1  
2  
3  
4 **BEFORE THE HEARING EXAMINER OF THE CITY OF MERCER ISLAND**

10 APPELLANT DANIEL GROVE'S  
11 NOTICE OF APPEAL OF BUILDING  
12 PERMIT NO. 2207-019

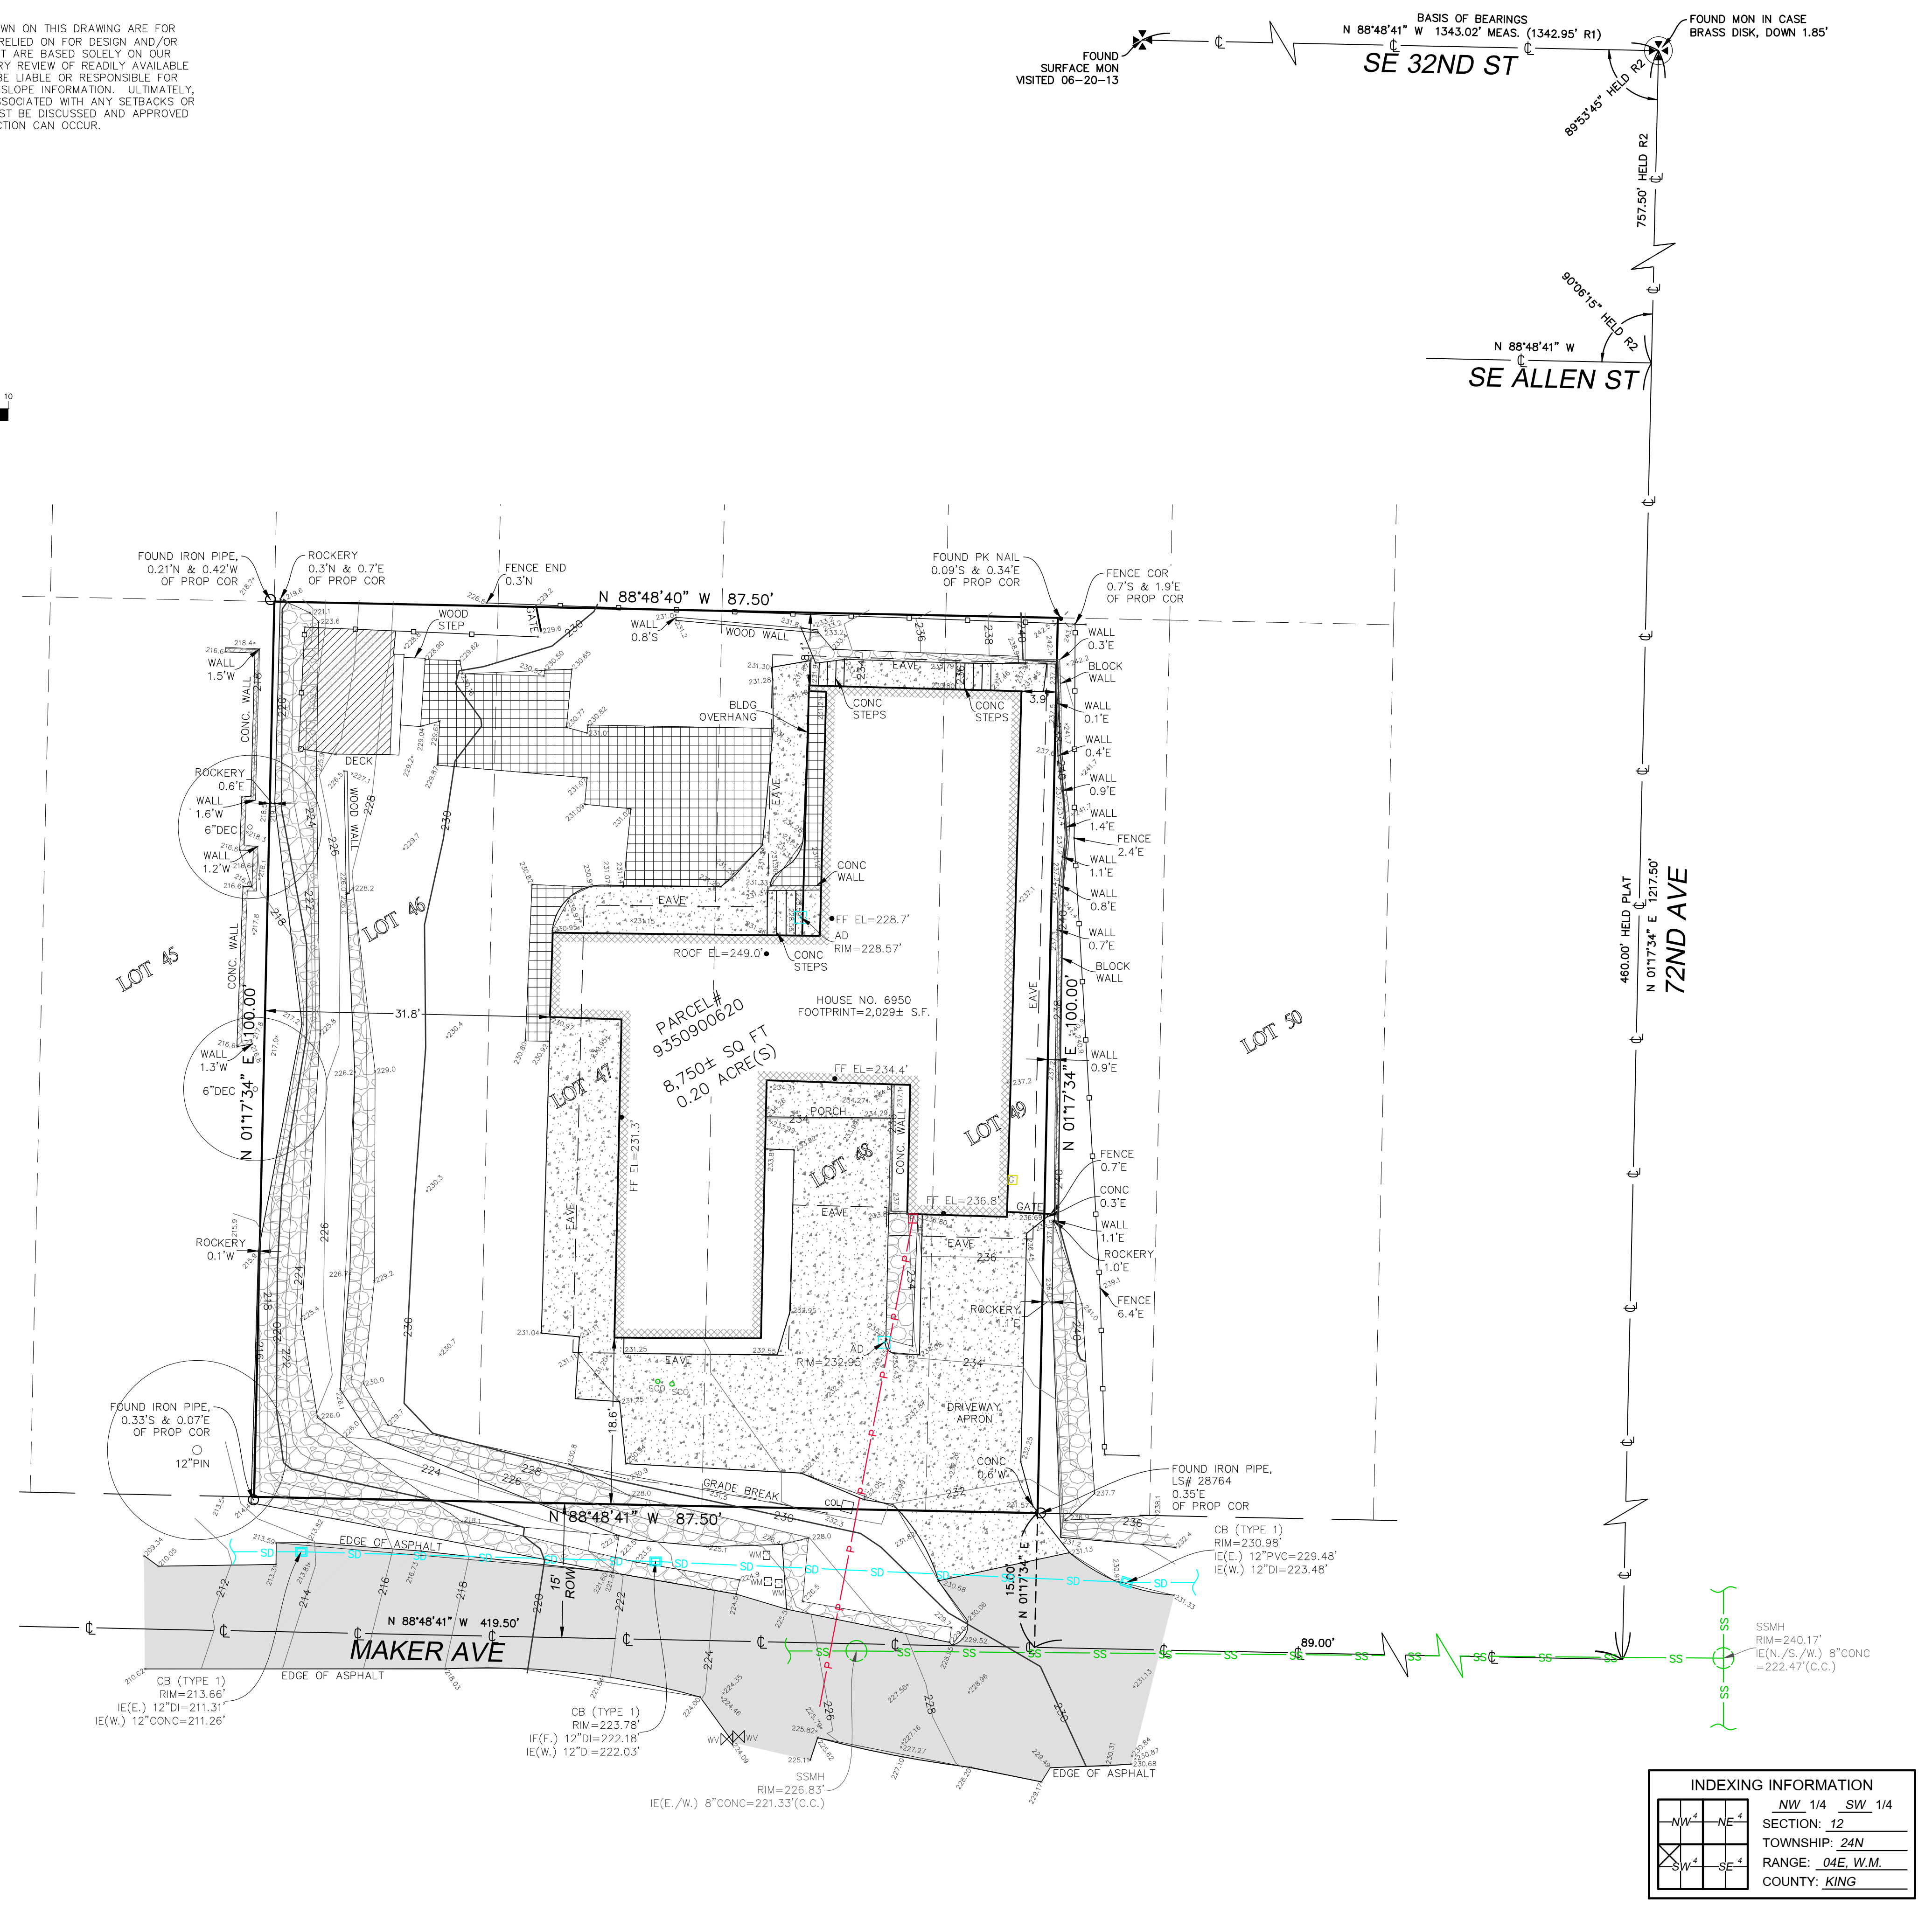
10            Any retaining walls/rockeries constructed as part of this proposal must conform with the  
11 current code requirements. Exhibit D (Sheet SH2).<sup>12</sup> The retaining walls/rockeries in the front yard,  
12 west yard and rear yards must comply with the height restriction of 72 inches per MICC  
13 19.02.050.D.5.b., measured from the top of the retaining wall or rockery to the existing grade or  
14 finished grade below it, whichever is lower. MICC 19.02.050.C.2. As previously determined, the  
15 dirt beneath the western and southern property perimeter is the “existing grade.”<sup>13</sup>

BASEMENT FLOOR PLAN

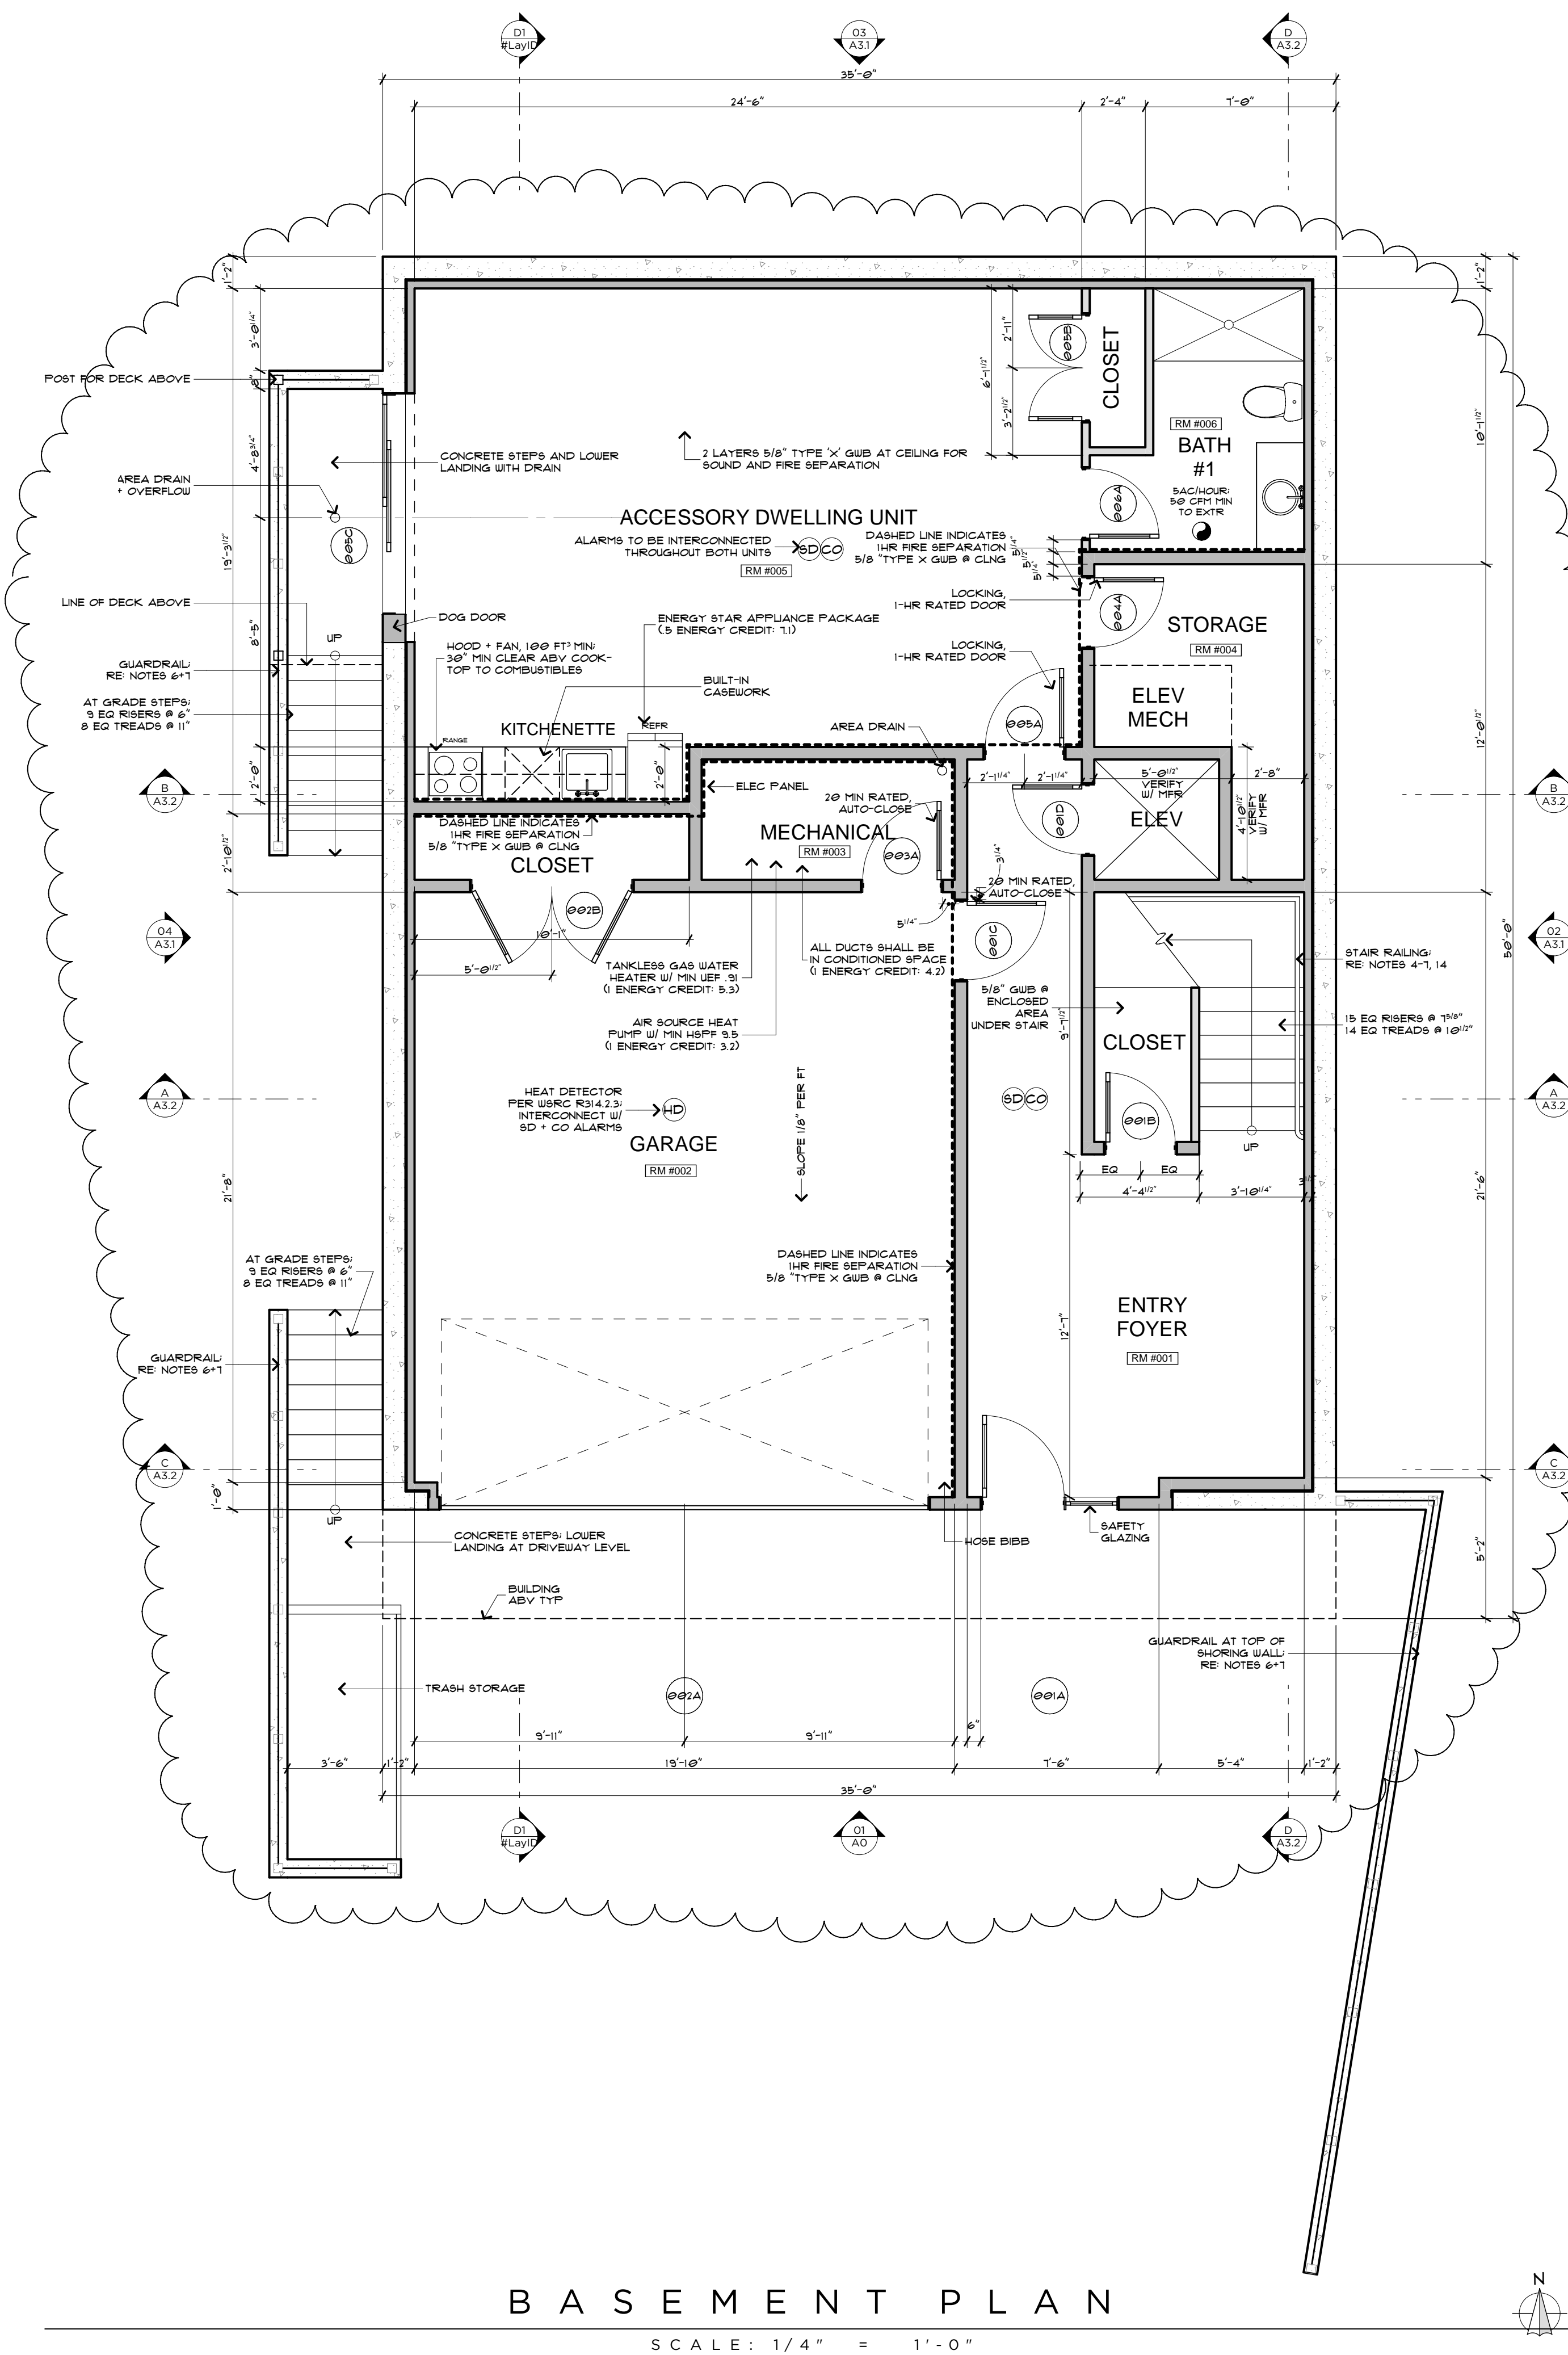
1 The incorrect existing and finished grade calculations resulted in a smaller basement floor  
2 exclusion area than is used in the Final Plan Set. The Final Plan Set calculates a basement floor  
3 exclusion area of 937.5 square feet. Exhibit D at A1.0. The actual basement exclusion area to be  
4 used is closer to 613 square feet. This results in a GFA for the proposed house that is approximately  
5 4,250 square feet, which is significantly larger than the permitted 3,937.5 square feet. As it stands,  
6 if not corrected, the City has permitted a house with a GFA that is roughly 300 to 350 square feet  
7 larger than the 3,937.5 square feet permitted.
